**Consultation Response from KC,
Lead Local Flood Authority**

2024/92365 Land off, Blackmoorfoot Road and Felks Street, Crosland Moor, Huddersfield, HD4 7AD

Date Responded: 27th November 2025

Responding Ref: 4

Title: **External Levels - Sheet 4**

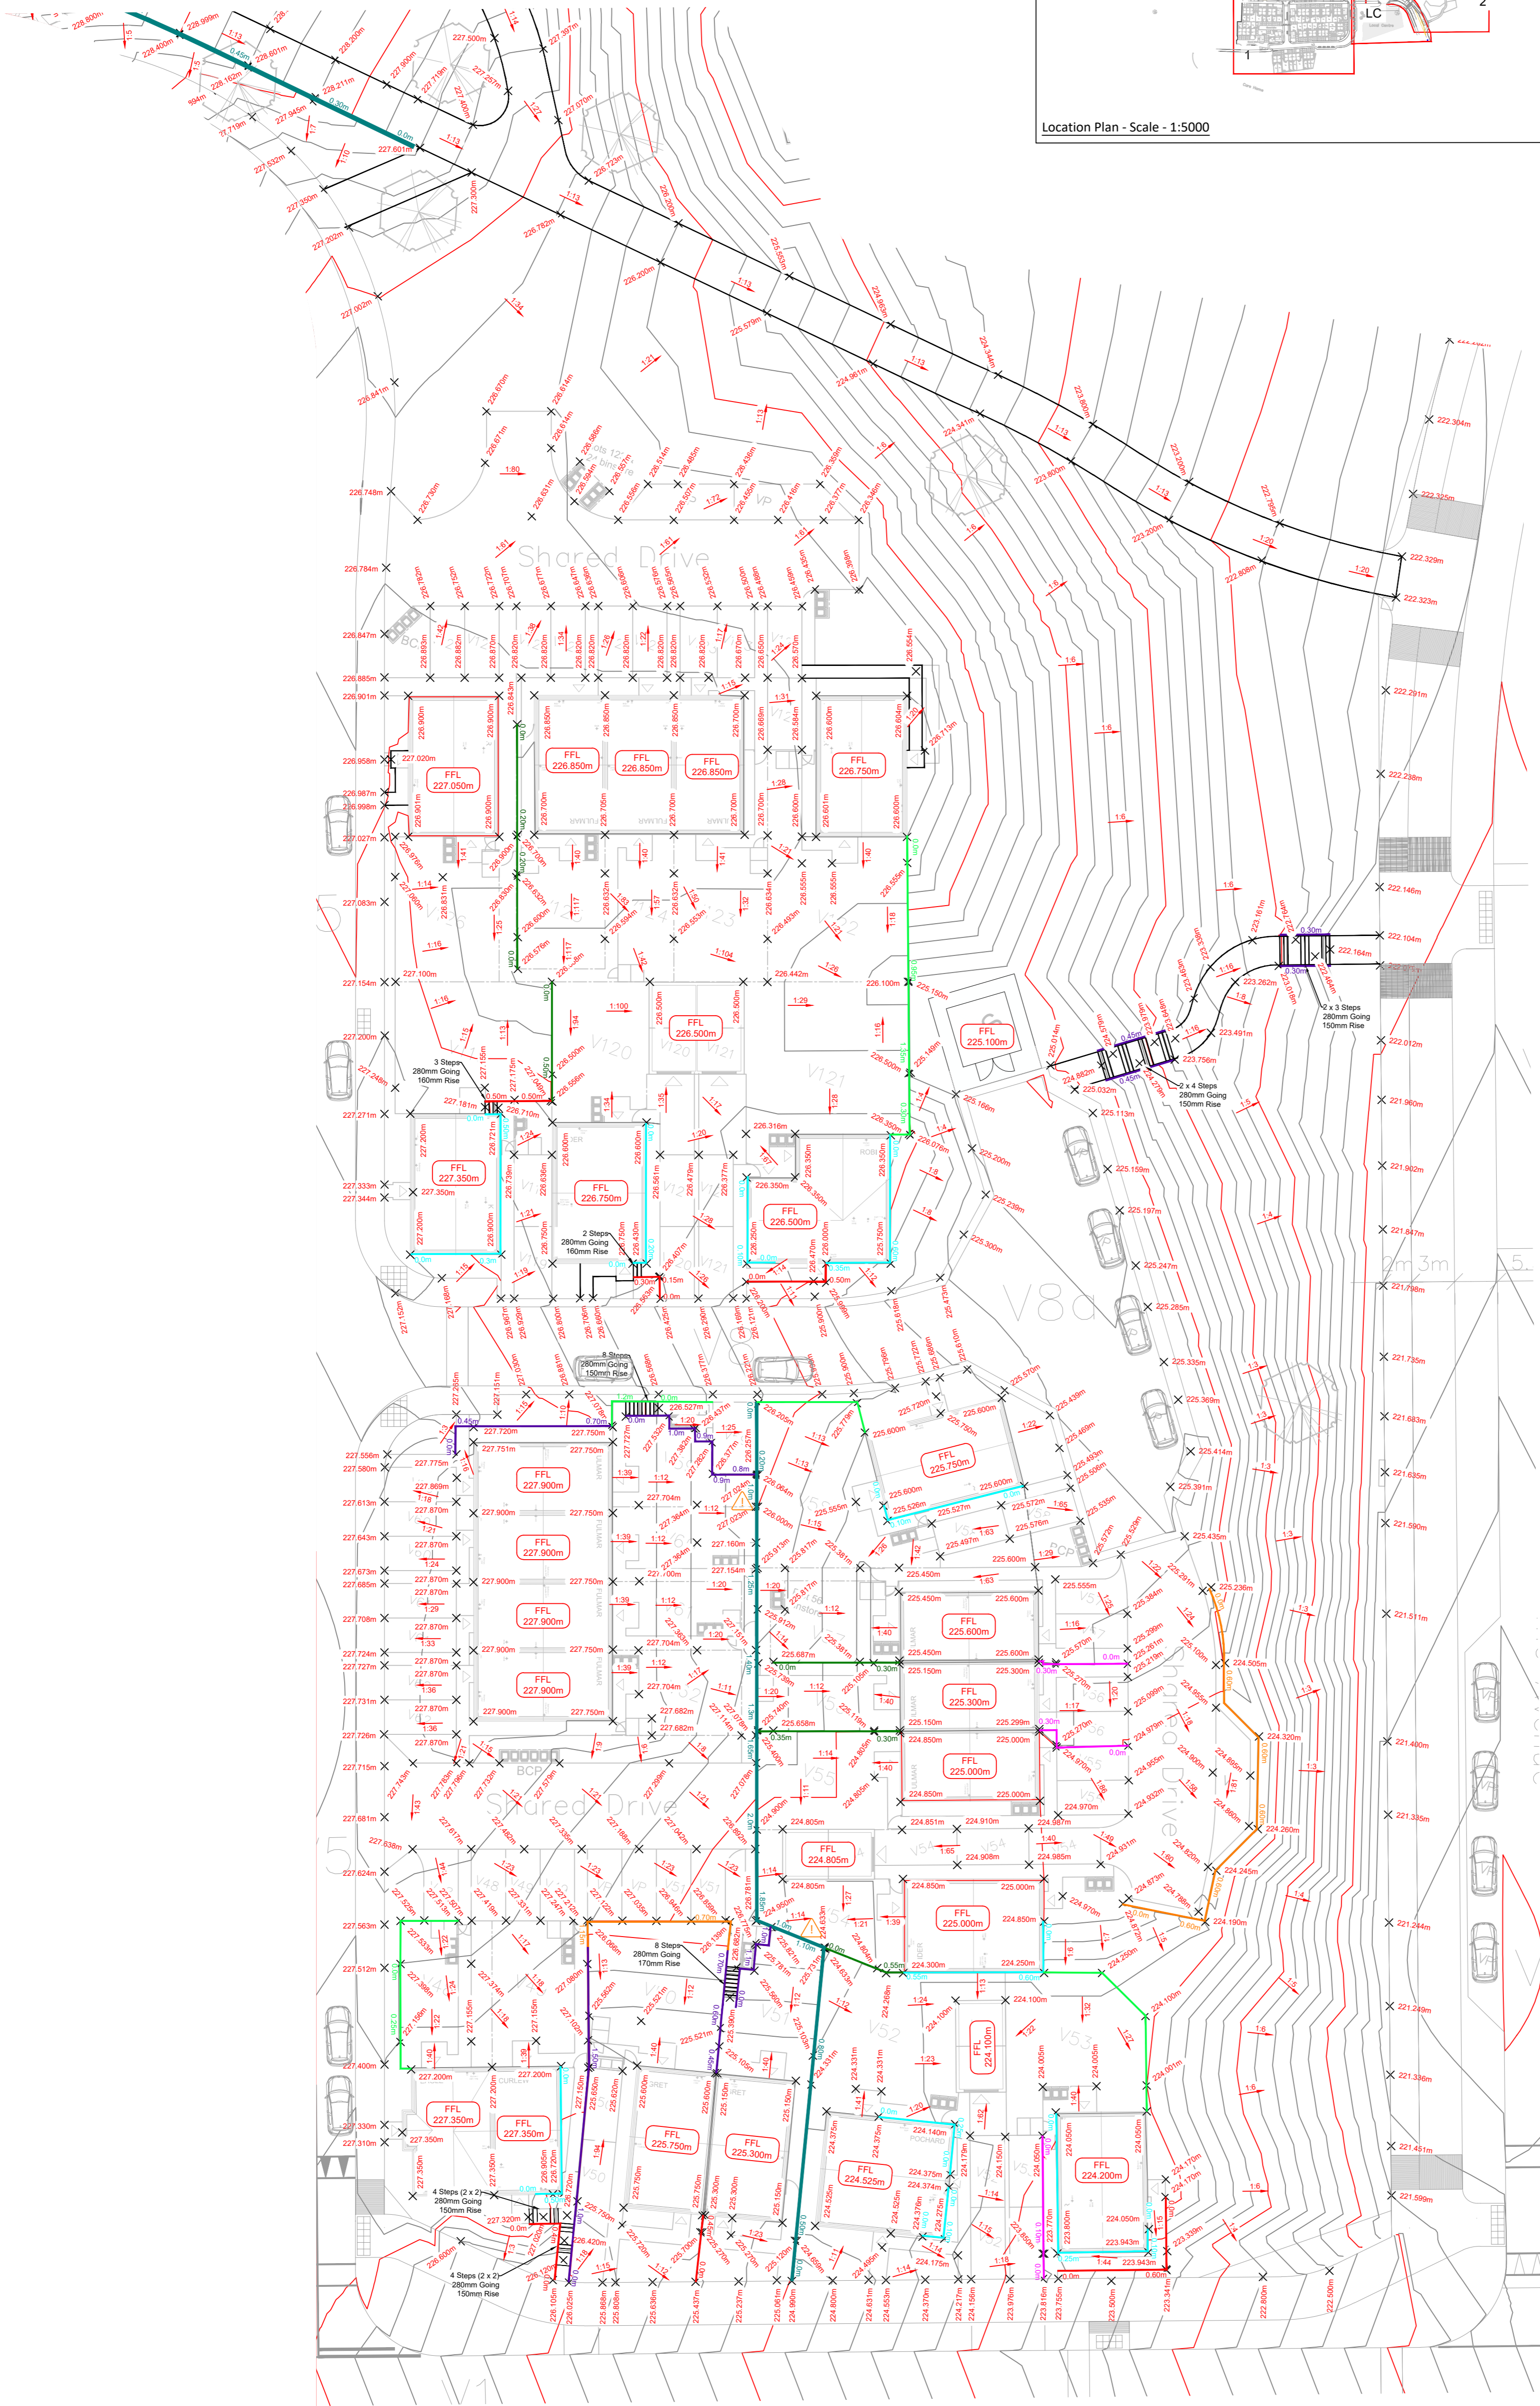
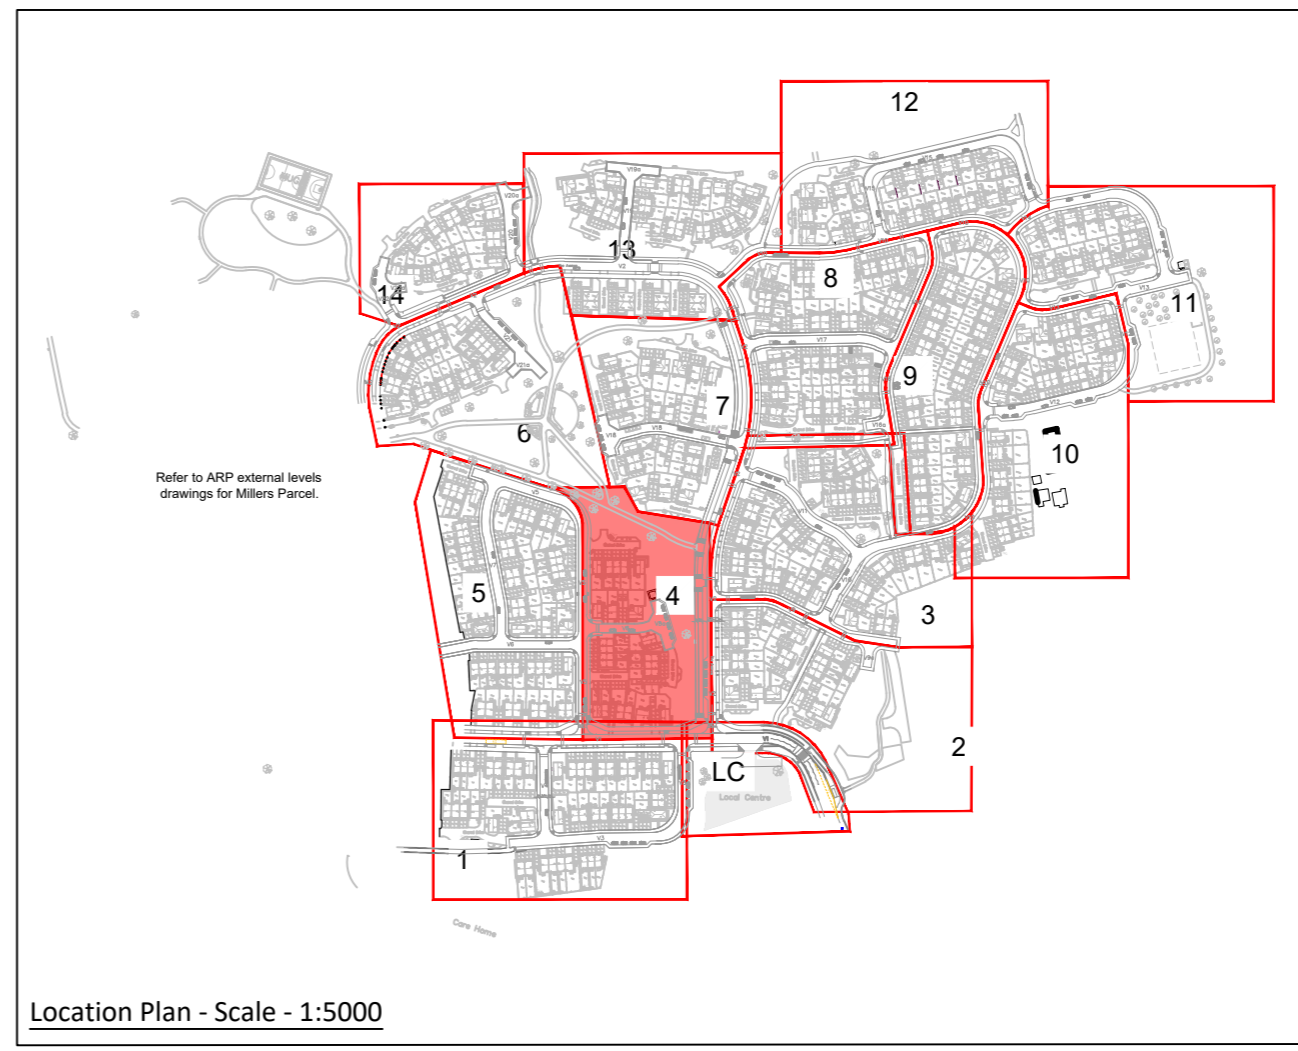
Further to our previous responses. Although contours in the road have still not been labelled there is enough back of kerb levels to determine directions of fall for flood routing purposes for the submitted layout.

There are some discrepancies between direction of flow on the detailed engineering layout in comparison to the flood routing layout showing directional arrows. For example, alongside plots 170-175, the relative drawings indicate flows in opposite directions to each other. However, for this cul-de-sac, routing would appear to be safe on both drawings.

There is still concern over plots 468/469 where directional arrows suggest flows along a shared drive and spot levels suggest flows toward the plots. In this instance we would look to the planning officer to see if these plots can be raised slightly to ensure the low spot is definitely along the safe route of the shared driveway, and resubmit drawings relative to this area.
